CITY OF ALBUQUERQUE

March 30, 2022

**Re: The Villa
205 7th St NW
Traffic Circulation Layout
Architect's Stamp 02-16-2022 (K14-D229)**

SITE FIRE PLAN

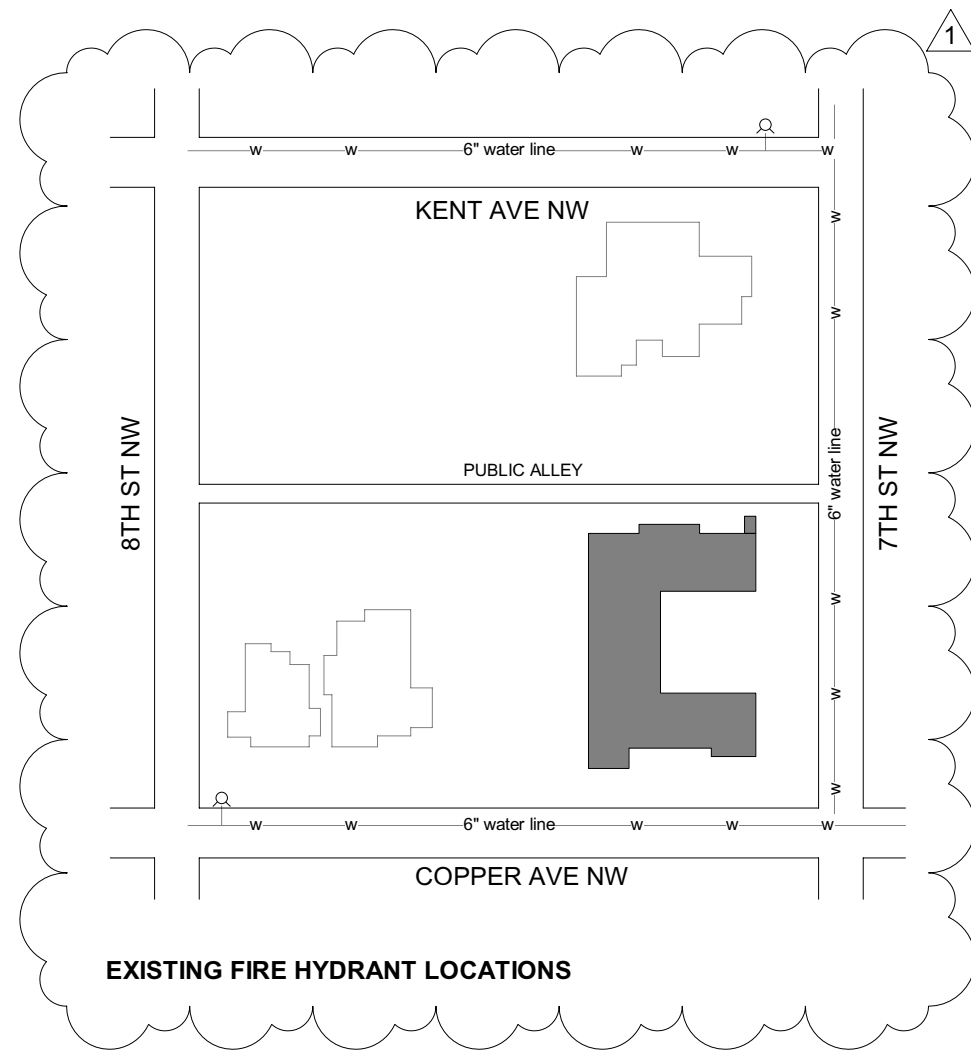
17. Fire Department: An approval Fire 1 plan needs to be provided.
18. It is not apparent what type of pavement surface is being proposed. A hard driving surface will be required as part of this proposed project for parking area, **ADA parking stalls** and drive aisles.

## A1 TRAFFIC CIRCULATION LAYOUT

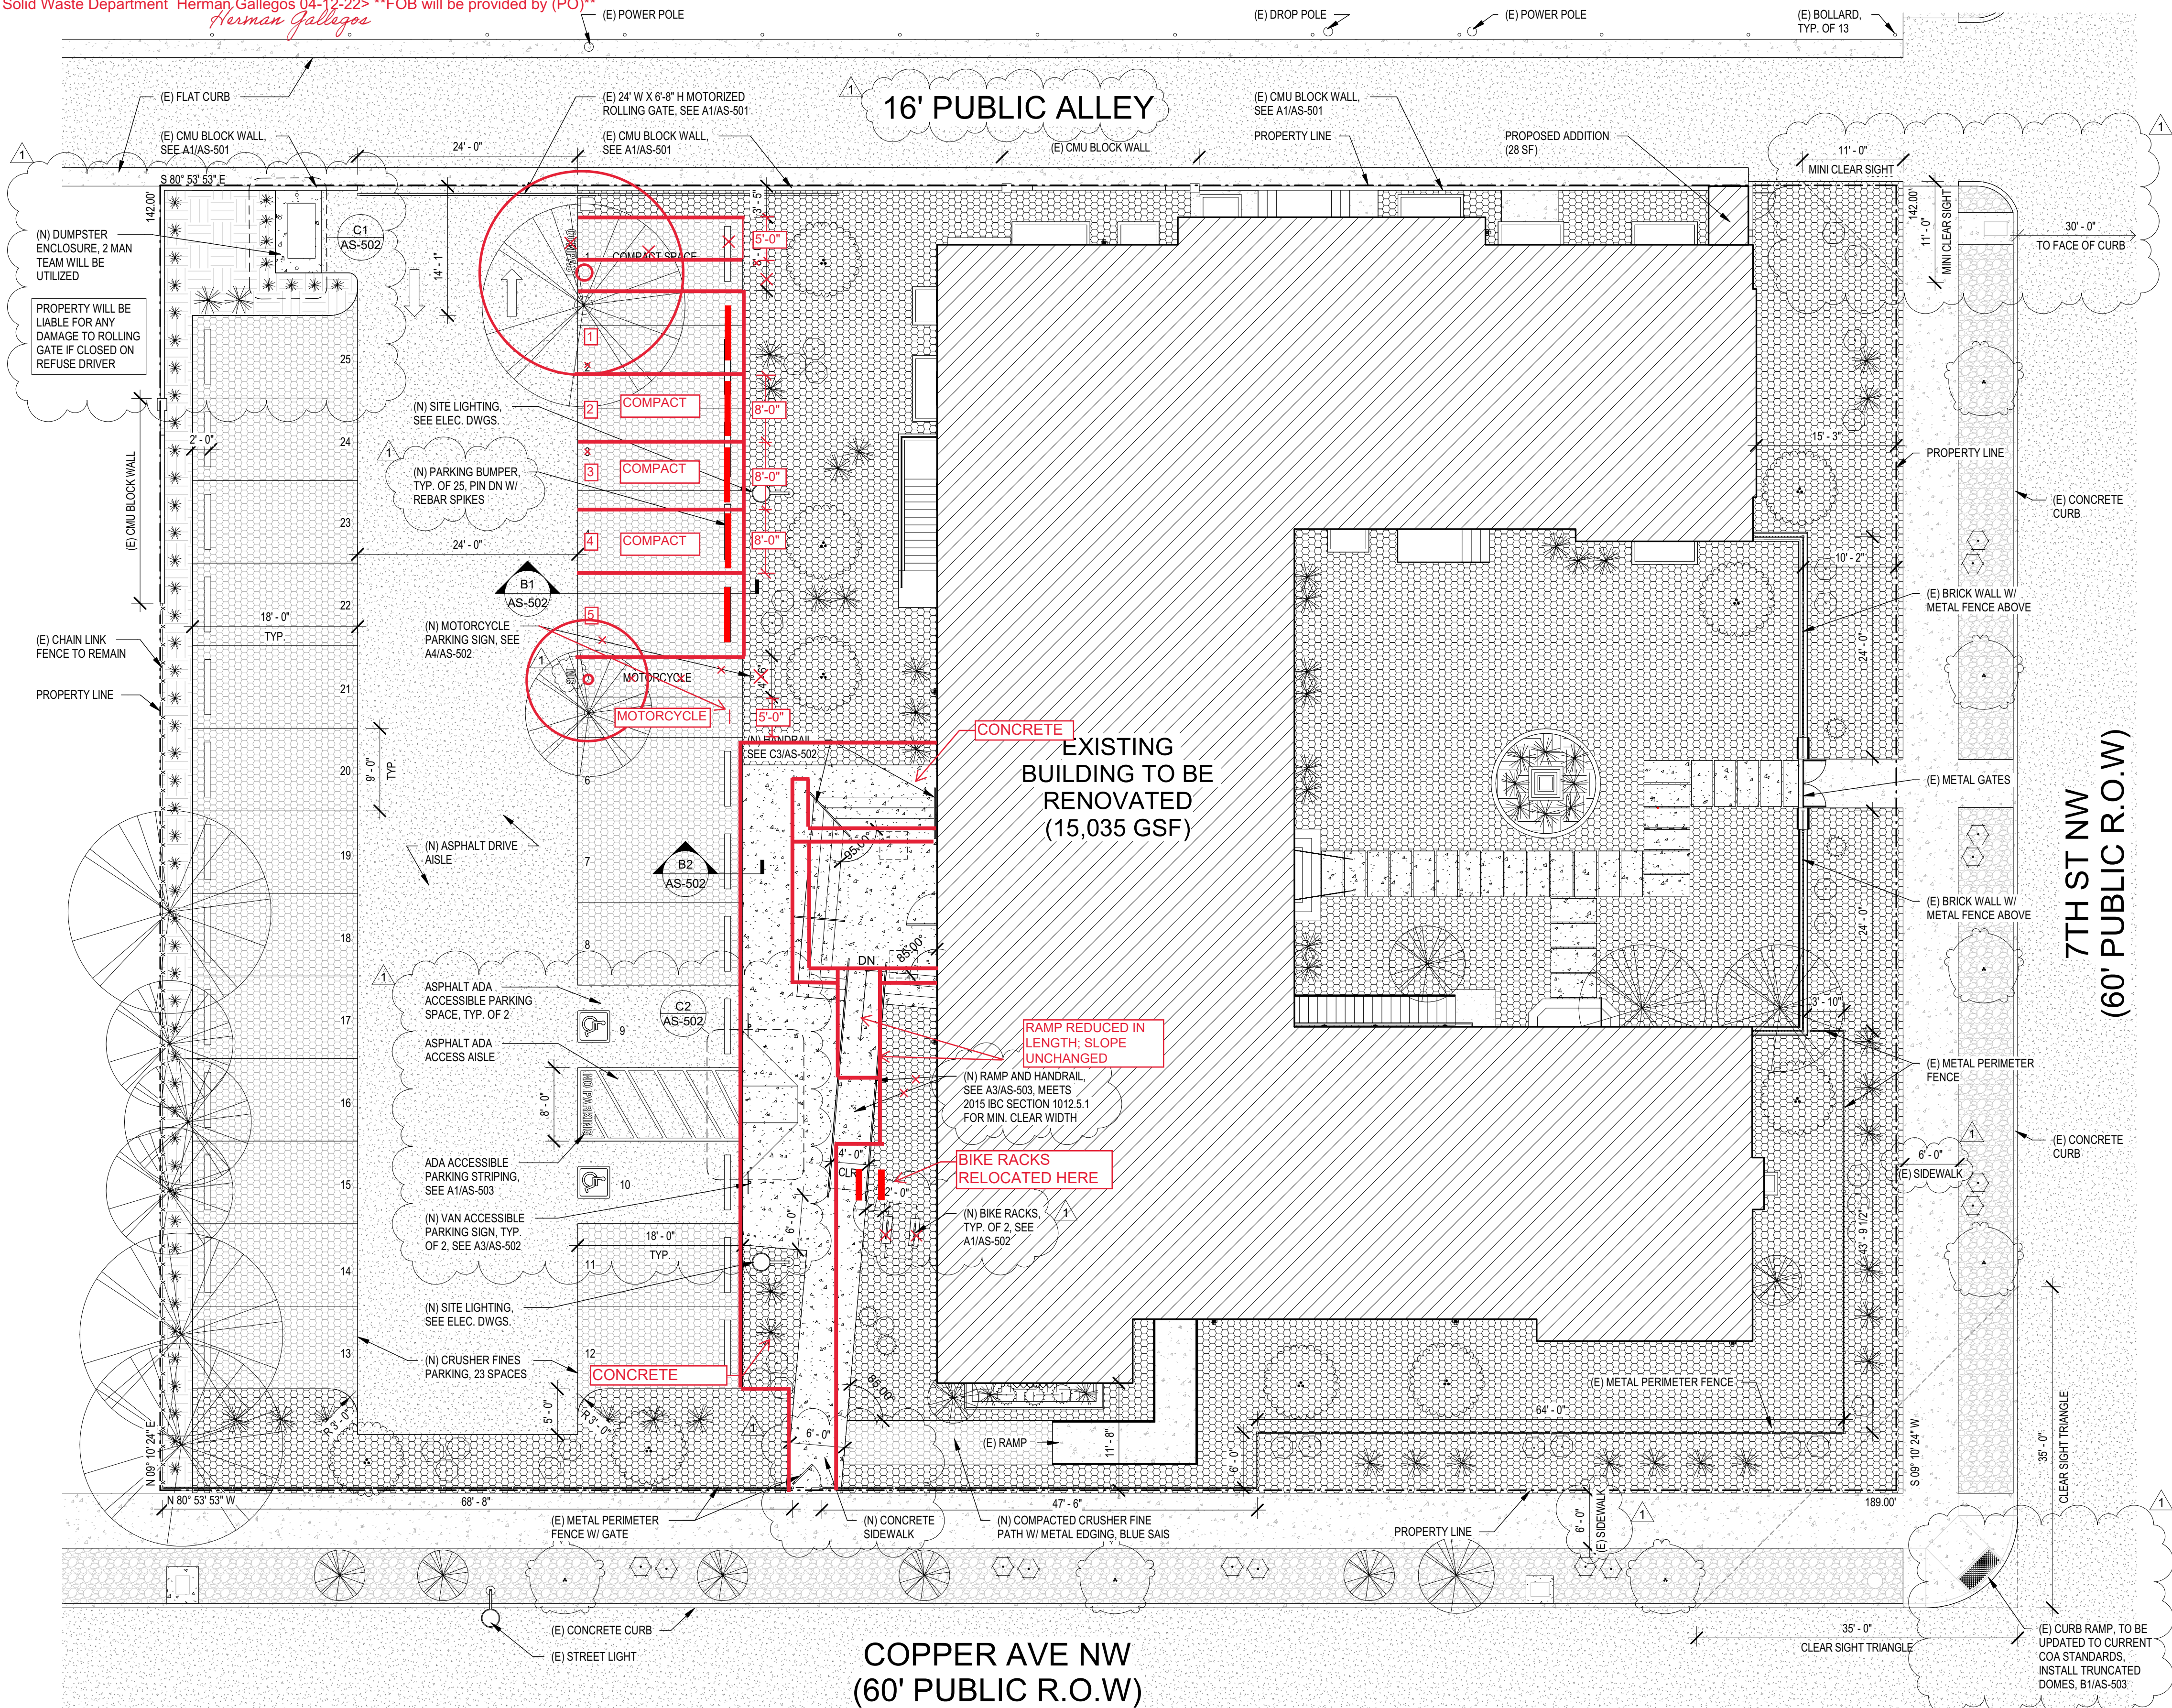
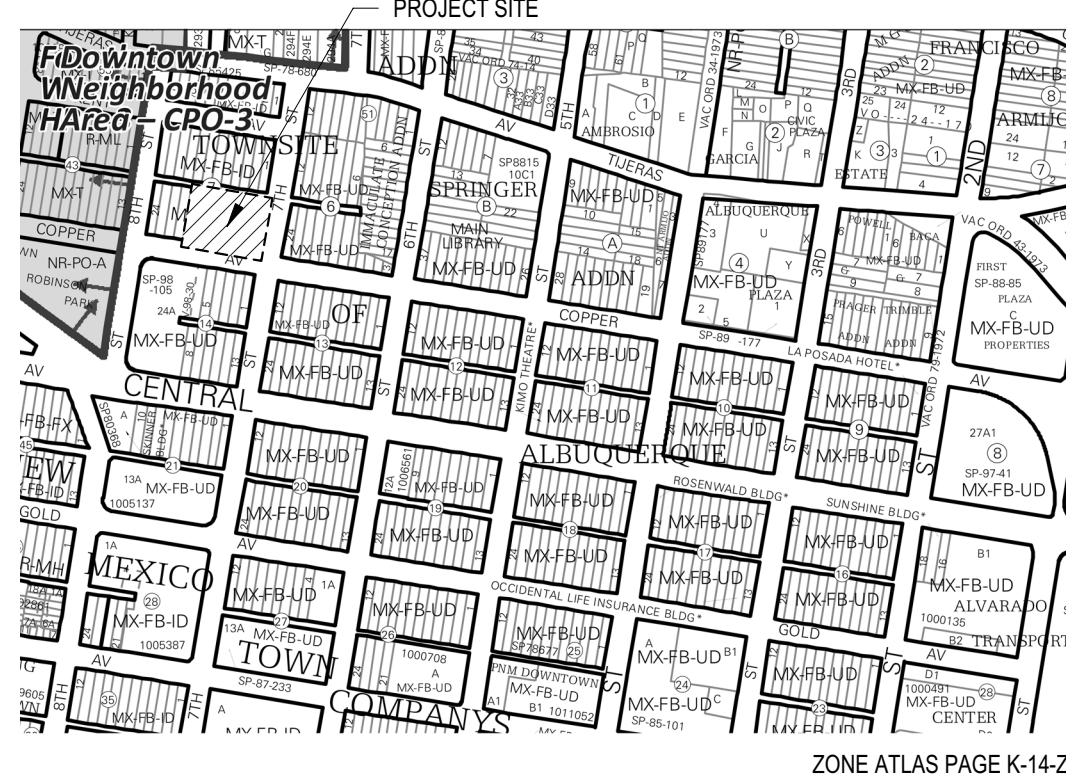
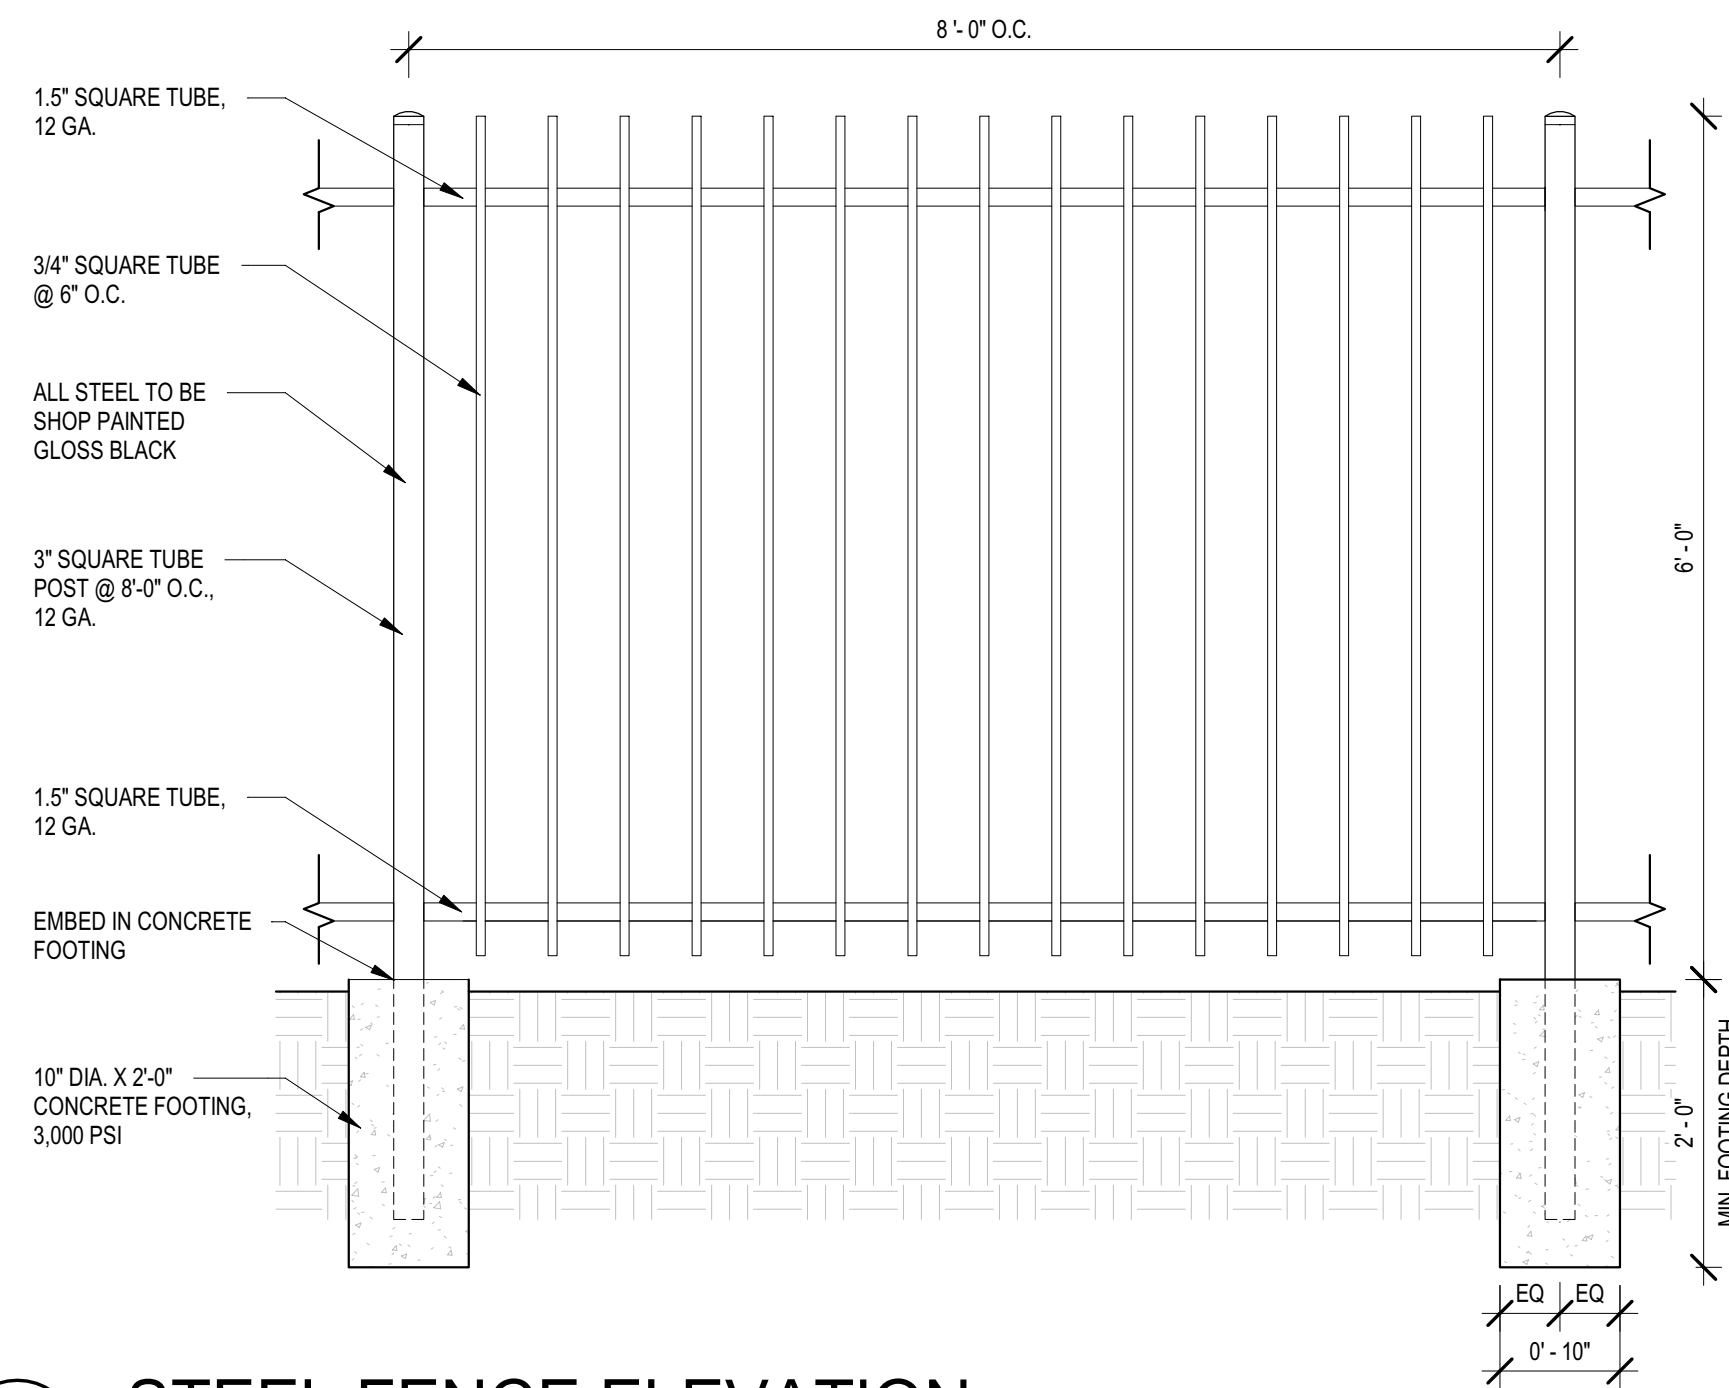
1. Listed are the number of parking spaces required by the IDO as well as the proposed number of parking spaces including bicycle and motorcycle parking.
Coordinate/discuss with Zoning.
2. Public Alley:
 - Flat curb is shown on alley way but not notes defining existing or proposed. If existing no comment but if proposed you will need a work order to to work with public ROW.
3. **Proposed ramp at ADA access aisle:**
 - Ramp will need to be locate on sidewalk and not protruding onto access aisle.
 - All transition wings will need to be **12:1 max** and not 10:1
 - Provide pavement marking will need detail.
4. **Parking bumper:** Provide detail.
5. **Proposed addition off Alley:** Door will need to swing inwards.
6. **The minimum parking stall dimensions are:**

13. Per the DPM, a 6 ft. wide **ADA accessible pedestrian pathway** is required from the public sidewalk to the building entrances. Please clearly show this pathway and provide details. Surface will need to be concrete/asphalt.

14. Per DPM, a 6 ft. wide **ADA accessible pedestrian pathway** is required from the ADA parking stall access aisles to the building entrances. Please clearly show this pathway and provide details.

15. All sidewalks along streets: Provide width.
16. Refuse vehicle maneuvering shall be contained on-site. **The refuse vehicle shall not back into the public right of way.** Provide a copy of refuse approval.

19. Please provide a sight distance exhibit at **Public Alley entrance**.
20. Please specify the City Standard Drawing Number when applicable.
21. Add a note stating "All broken or cracked sidewalk must be replaced with sidewalk and curb & gutter." A build note must be provided referring to the appropriate City Standard drawing (2430 & 2415A).

**C2** CURB RAMP DETAIL  
SCALE: 1/2" = 1'-0"

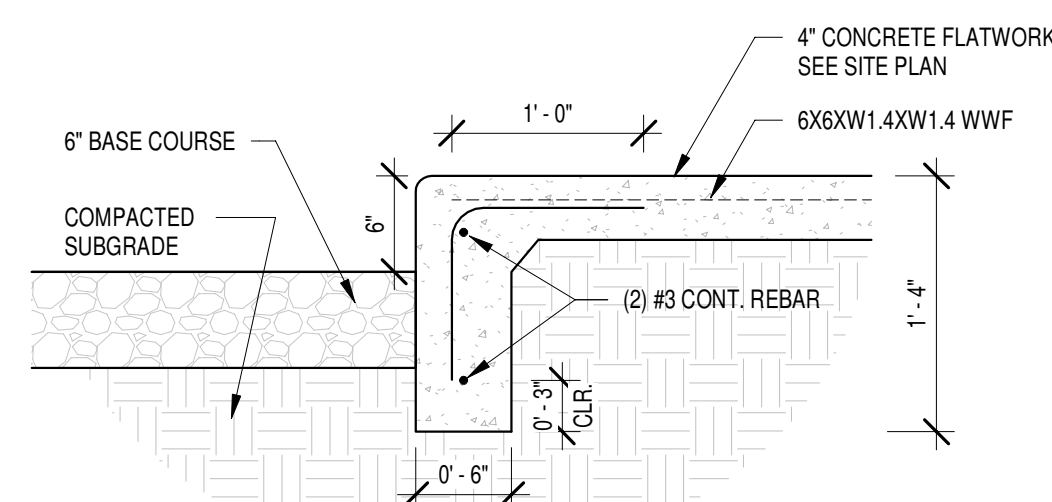
8. ADA curb ramps must be updated to current standards and have truncated domes installed (**Corner of Copper/7th St.**).
9. All bicycle racks shall be designed according to the following guidelines:

A1 ACCESSIBLE PARKING STRIPING DETAIL  
SCALE: 1/4" = 1'-0"

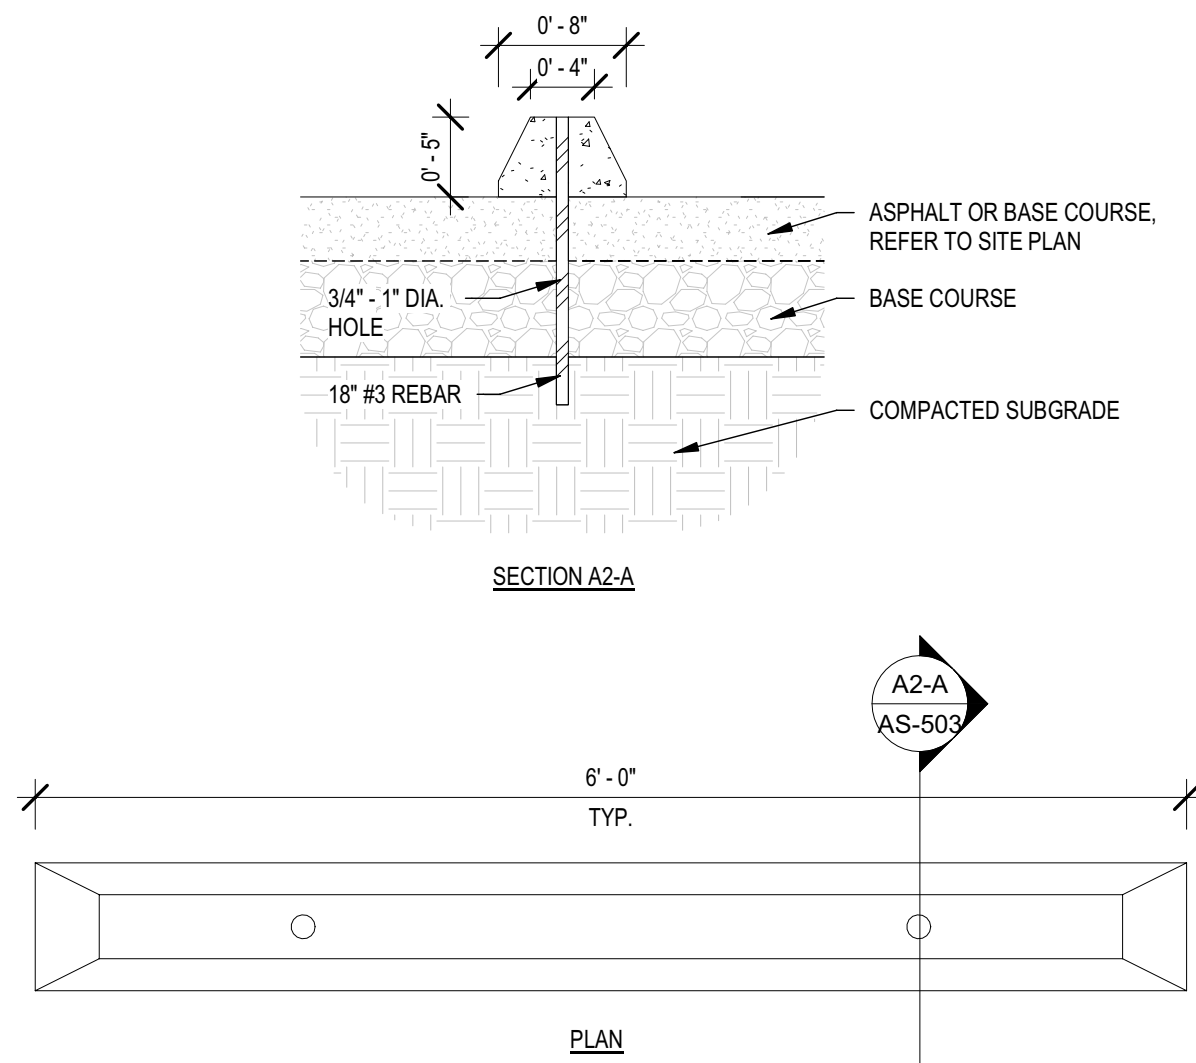
7. The ADA access aisles shall have the words **"NO PARKING"** in capital letters, each of which shall be at least one foot high and at least two inches wide, placed at the rear of the parking space so as to be close to where an adjacent vehicle's rear tire would be placed. (66-1-4.1.B NMSA 1978)
